**PROPOSED:**  
 MULTI-FAMILY DEVELOPMENT  
 4540 Providence Road  
 Charlotte, NC 28226

**PETITION #**  
 2005-087

**CHARLOTTE - MECKLENBURG  
PLANNING COMMISSION**

**SUBJECT:** Administrative Approval for Petition No. 2005-87 by Blue Sky Partners.

SITE PLAN
 SCALE: 1" = 20'-0"

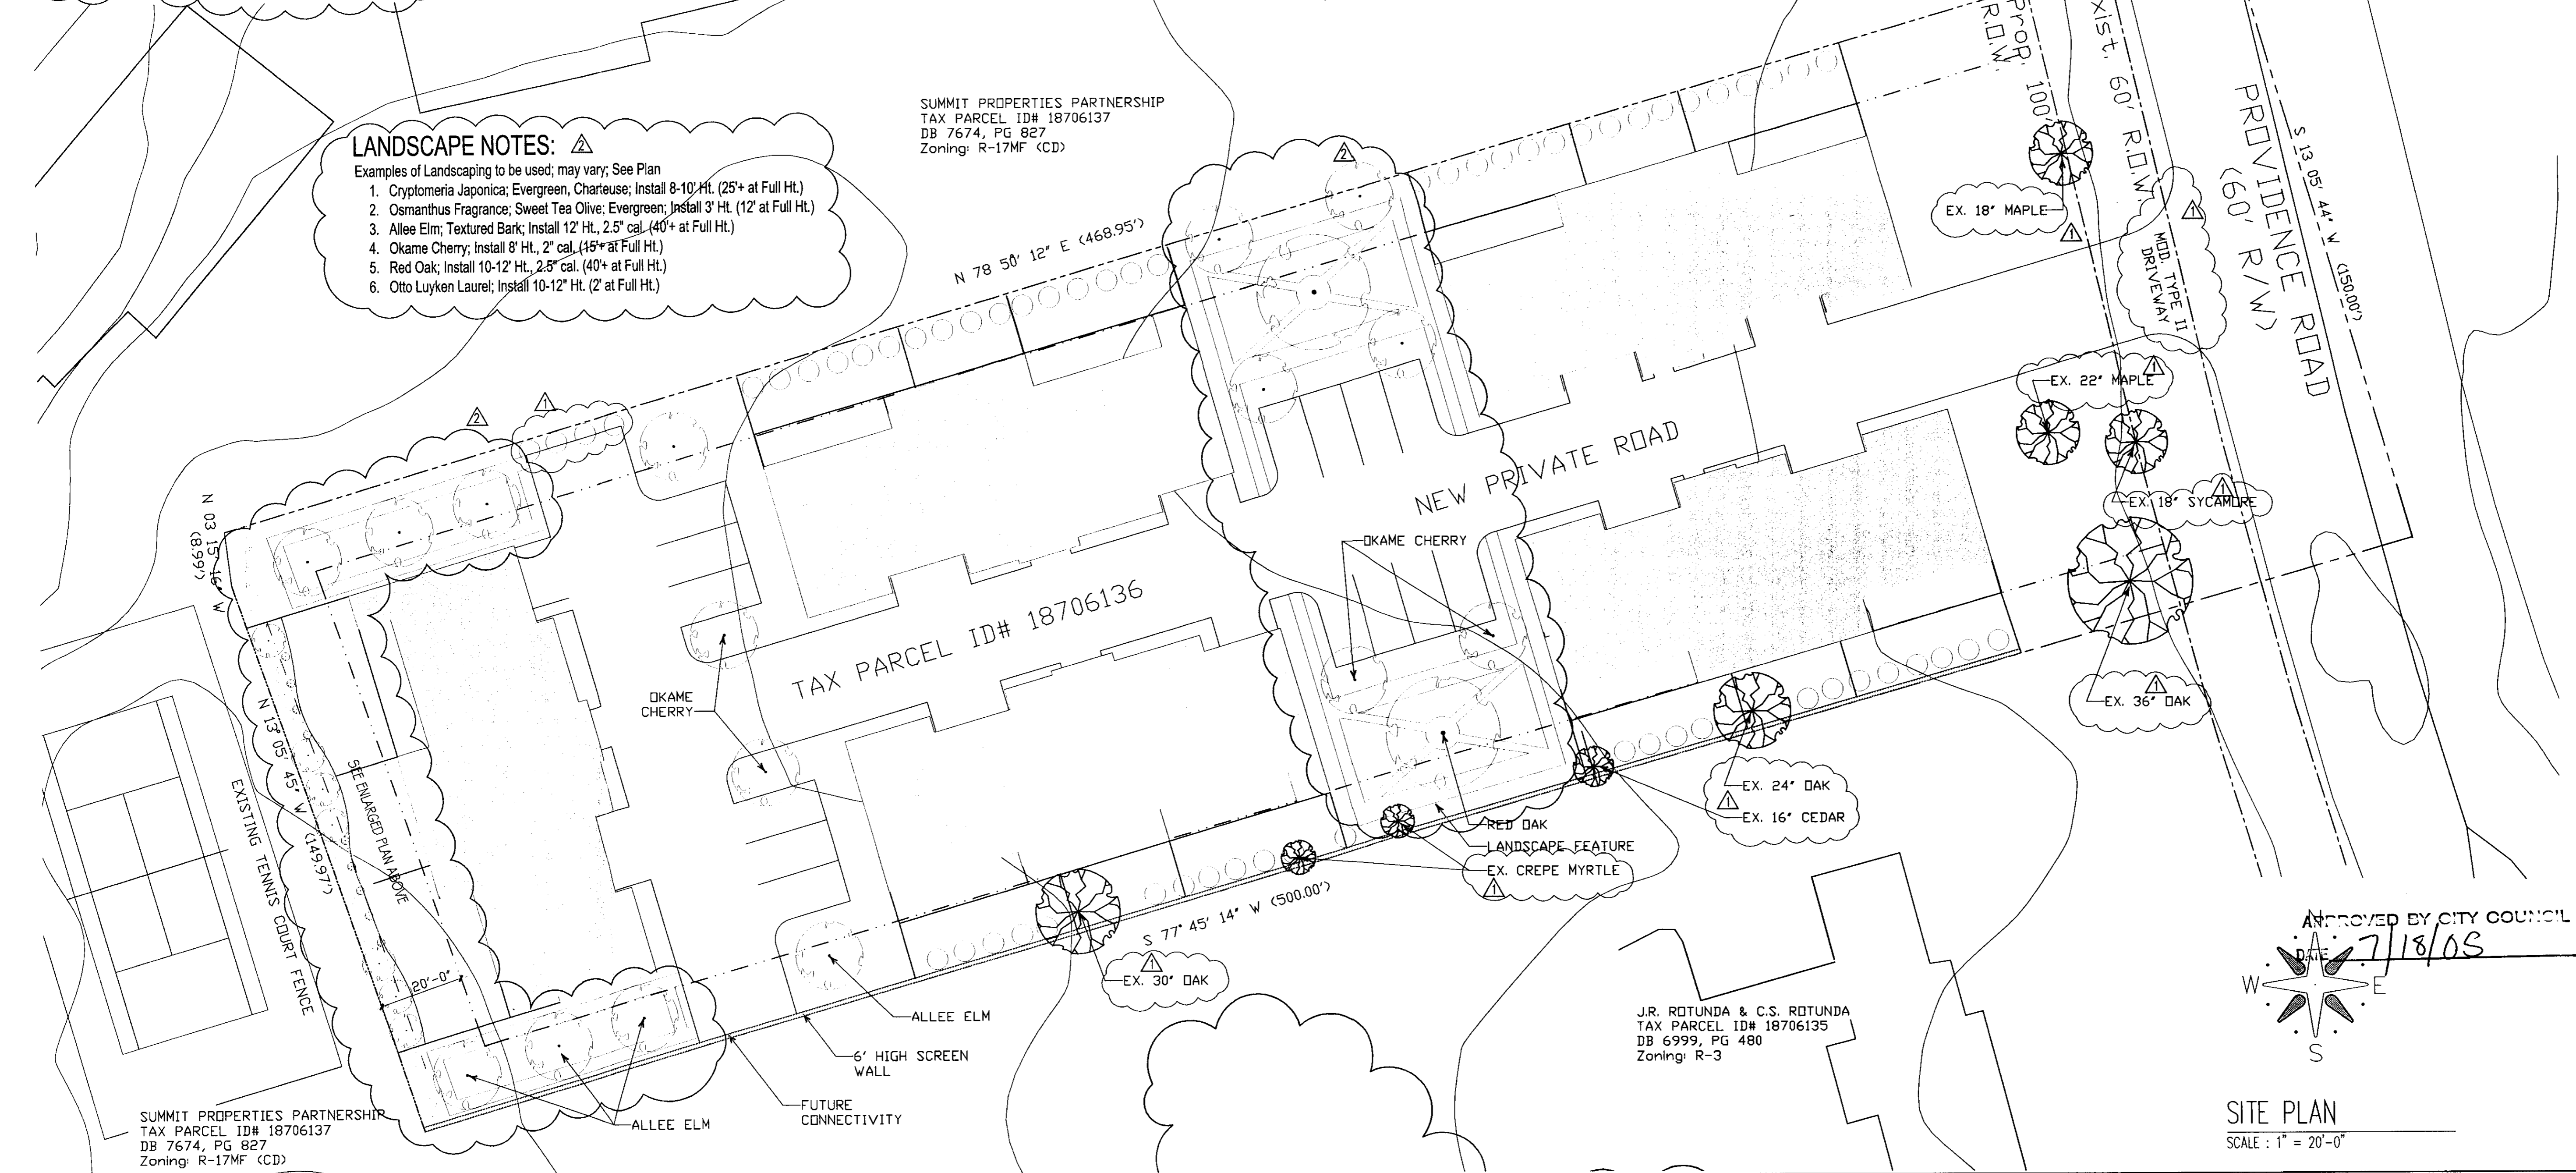
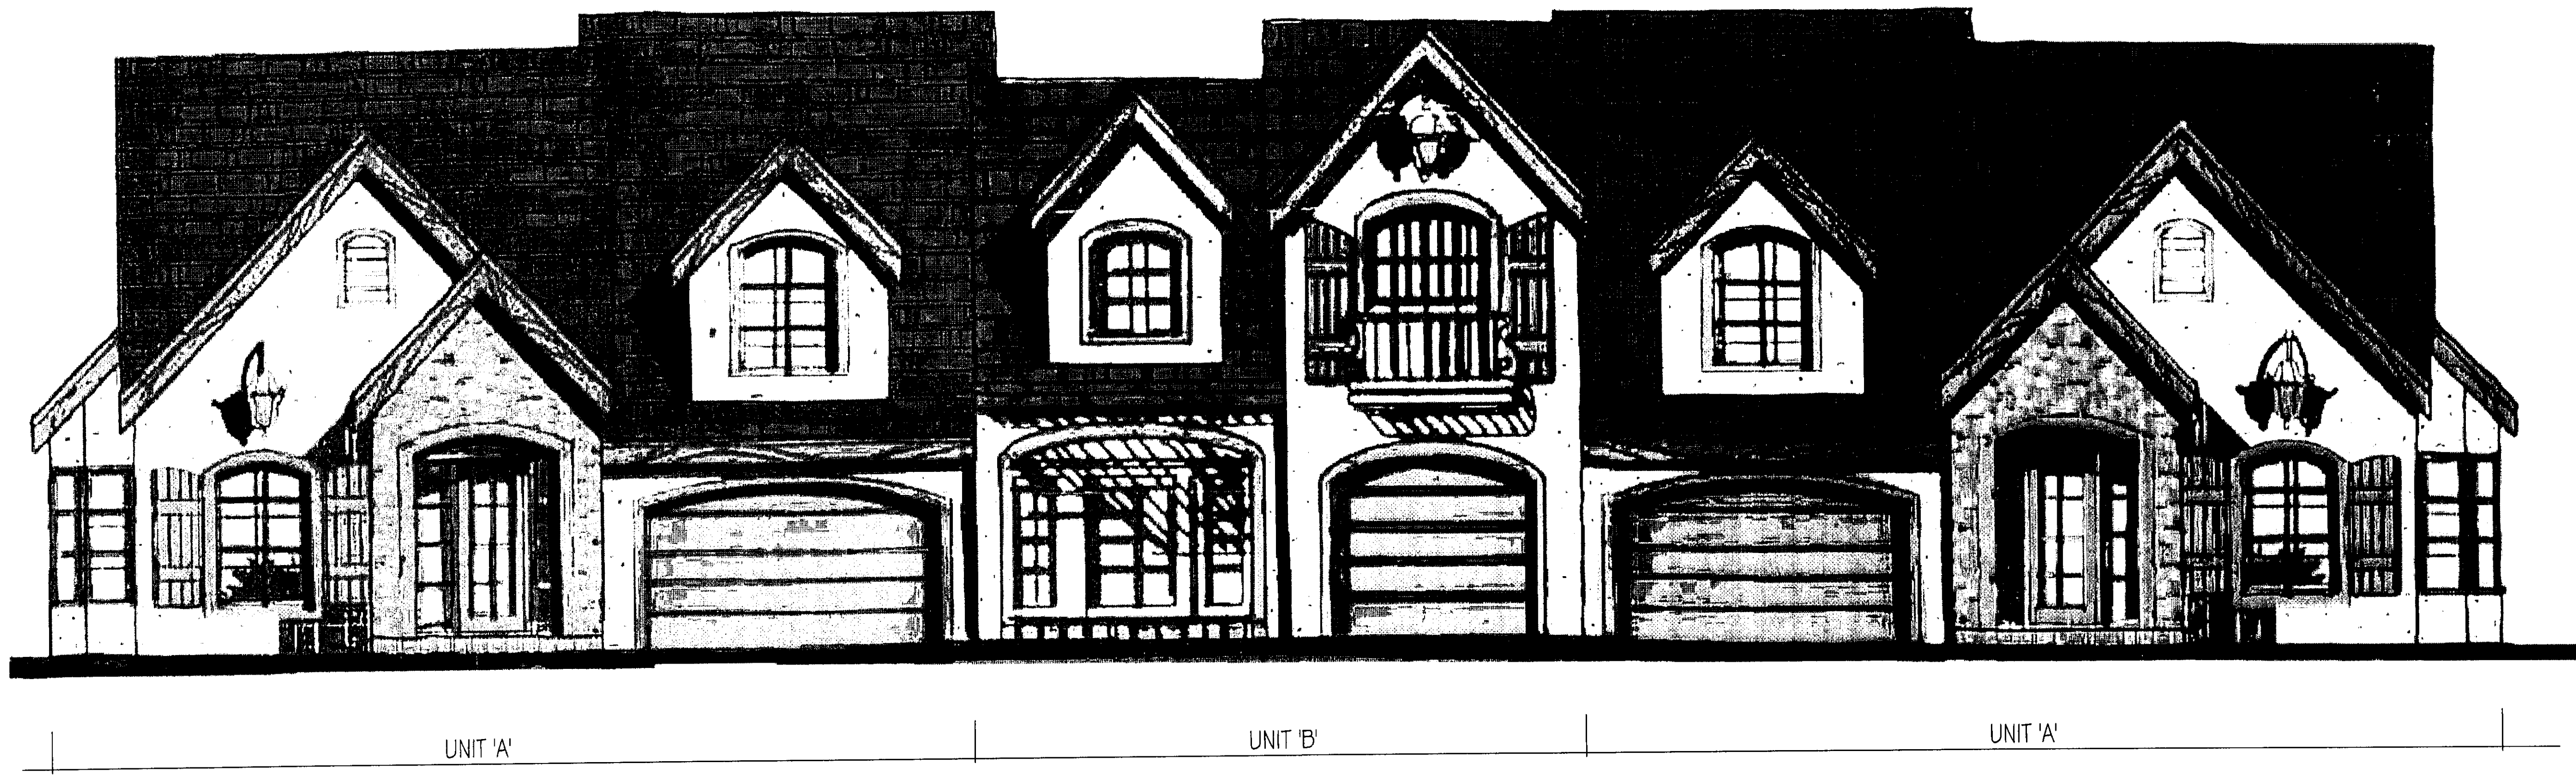
Attached is a revised plan and building elevations for the above petition. The plans indicate a reduction of the rear yards to ten feet and minor changes to the building elevations. Since these changes are minor and allowed by the Zoning Ordinance, I am administratively approving this revised plan. Please use this plan when evaluating requests for building permits and certificates of occupancy.  
**Note that all other ordinance and signage requirements still apply.**
